Re: Gardiner

Subject: RE: Planning Consultation on: LU/241/13/L

APPLICATION LU/241/13/L

2013
Site Address: Toddington House Toddington Lane Littlehampton BN17 6JX
Grid Reference: 503424 103745
Description of Works: Application for Listed Building Consent for the demolition of single storey pantry to north elevation and erection of kitchen extension.

A NEW KITCHEN EXTENSION
 AT • TODDINGTON HOUSE •
 LITTLEHAMPTON. ©. 10th MAY 2013
 FOR • MR & MRS M. WAROM • DRWG. N° 740/P03-

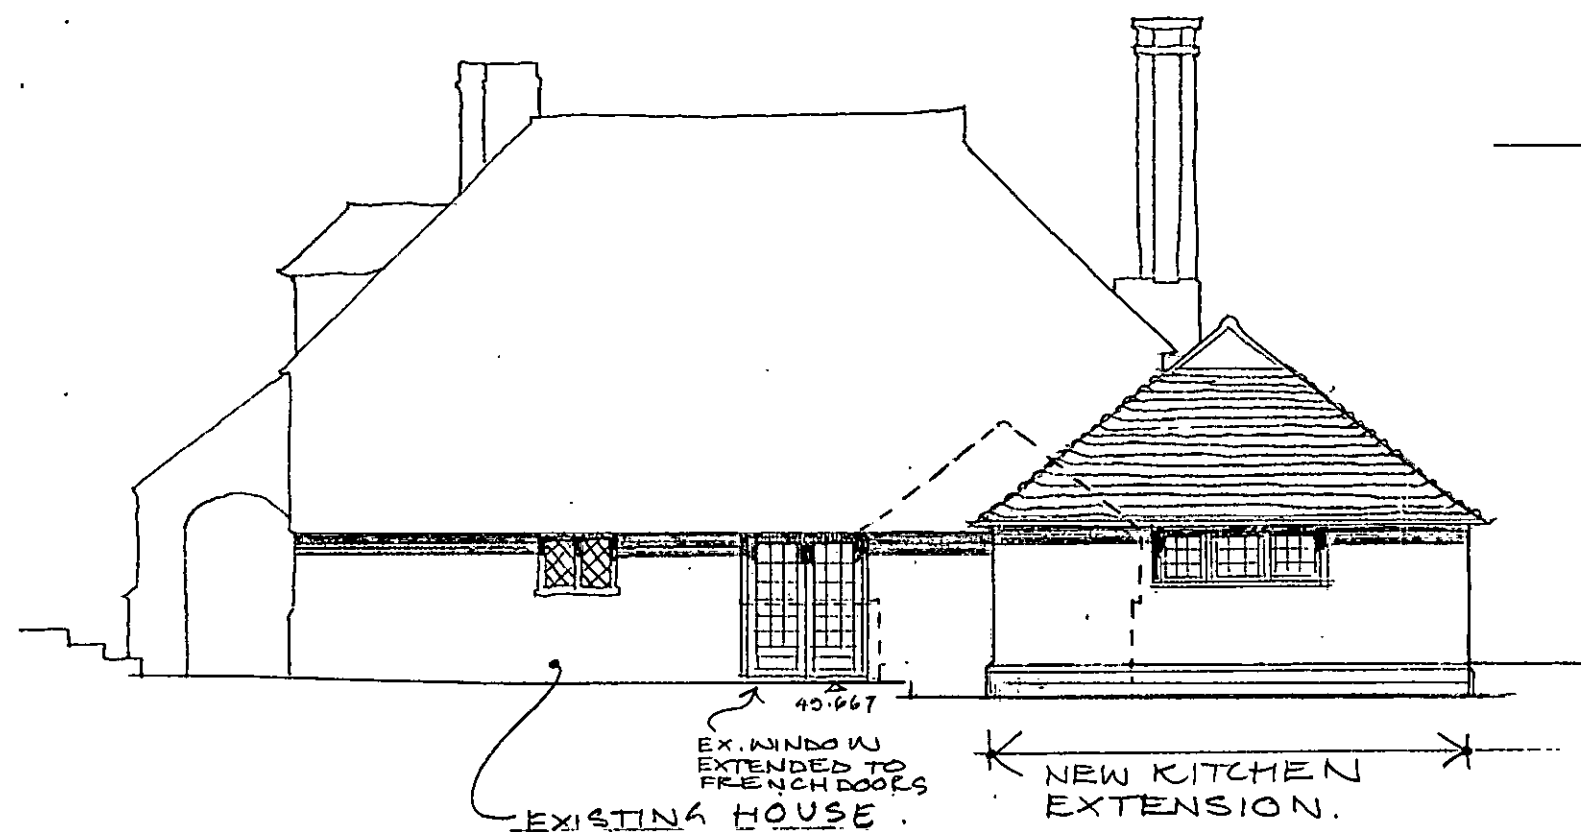
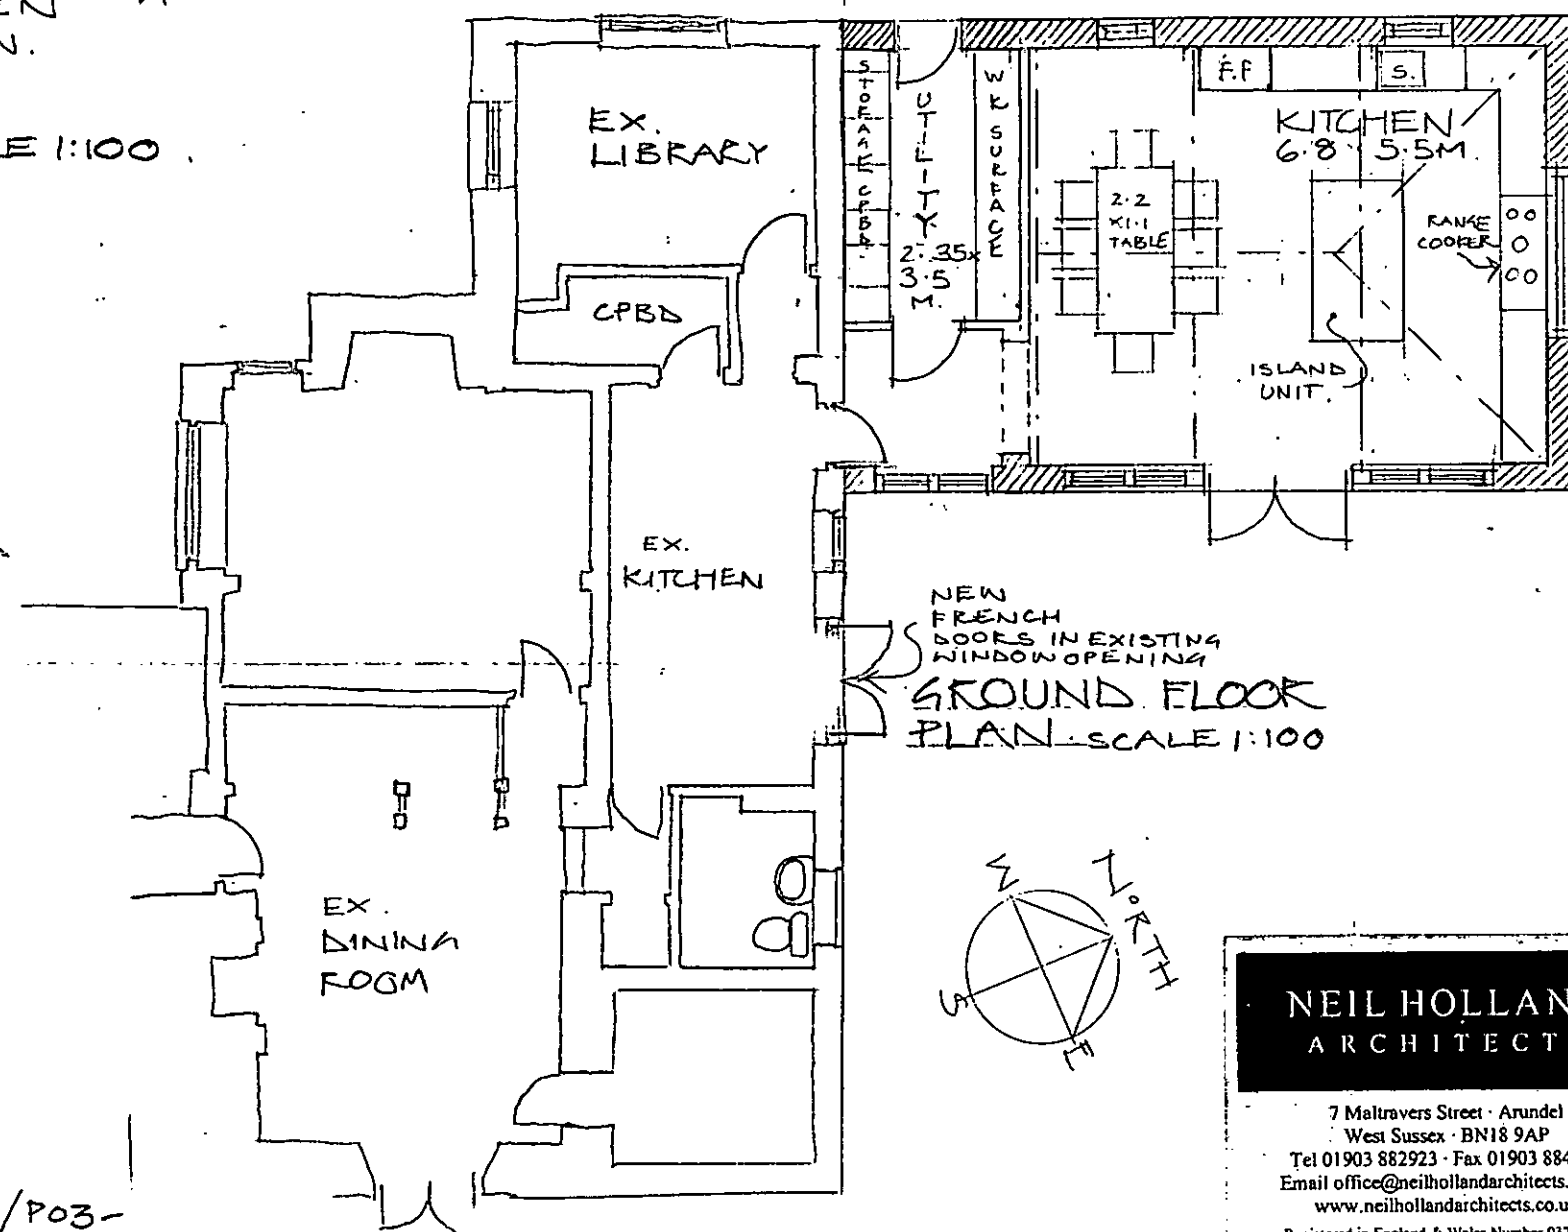
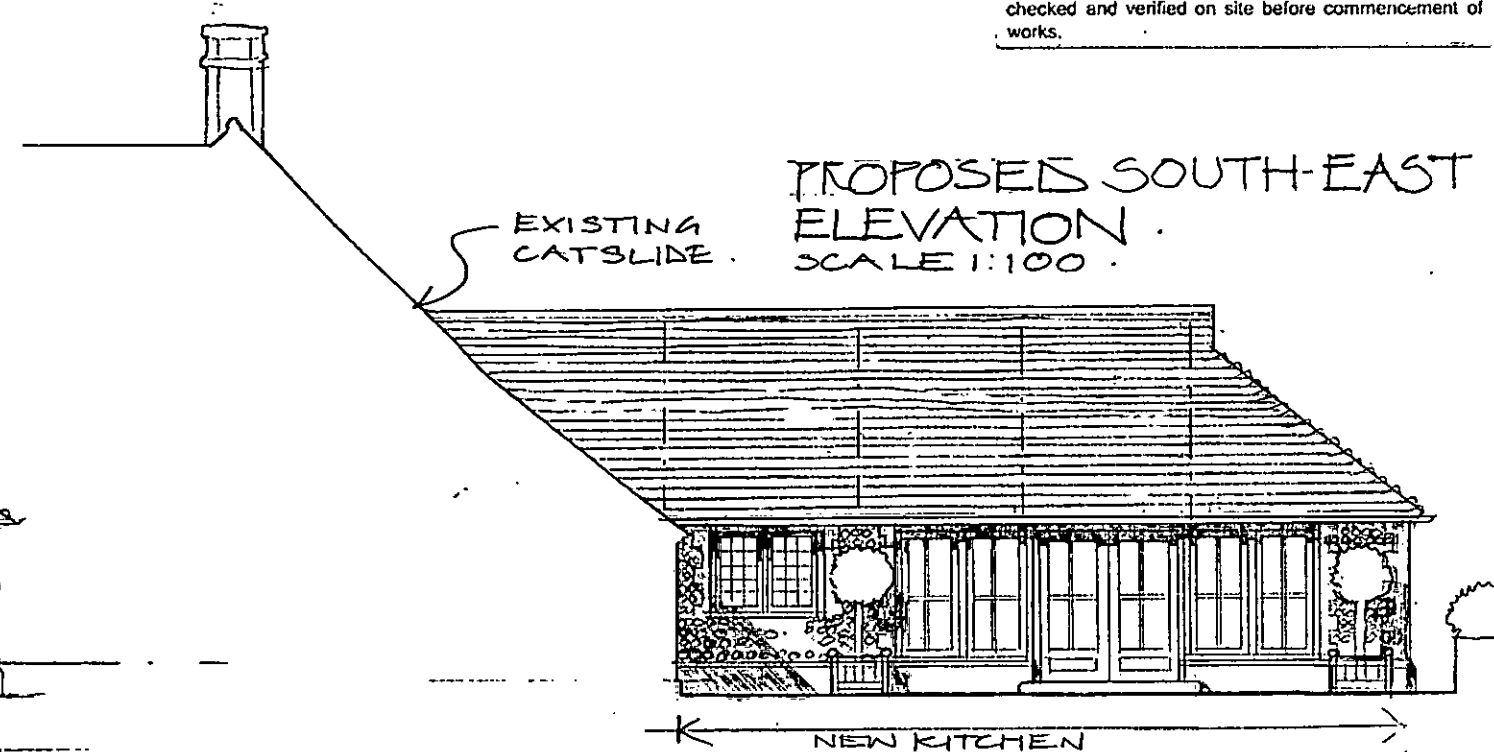
Accordingly, without prejudice, I would welcome receipt of amended plans reducing the length of the extension by approx. 2.5 metres. It would also be useful if the extract of the proposed ground floor plan could indicate the proposed uses of the ex. dining room, kitchen and library.
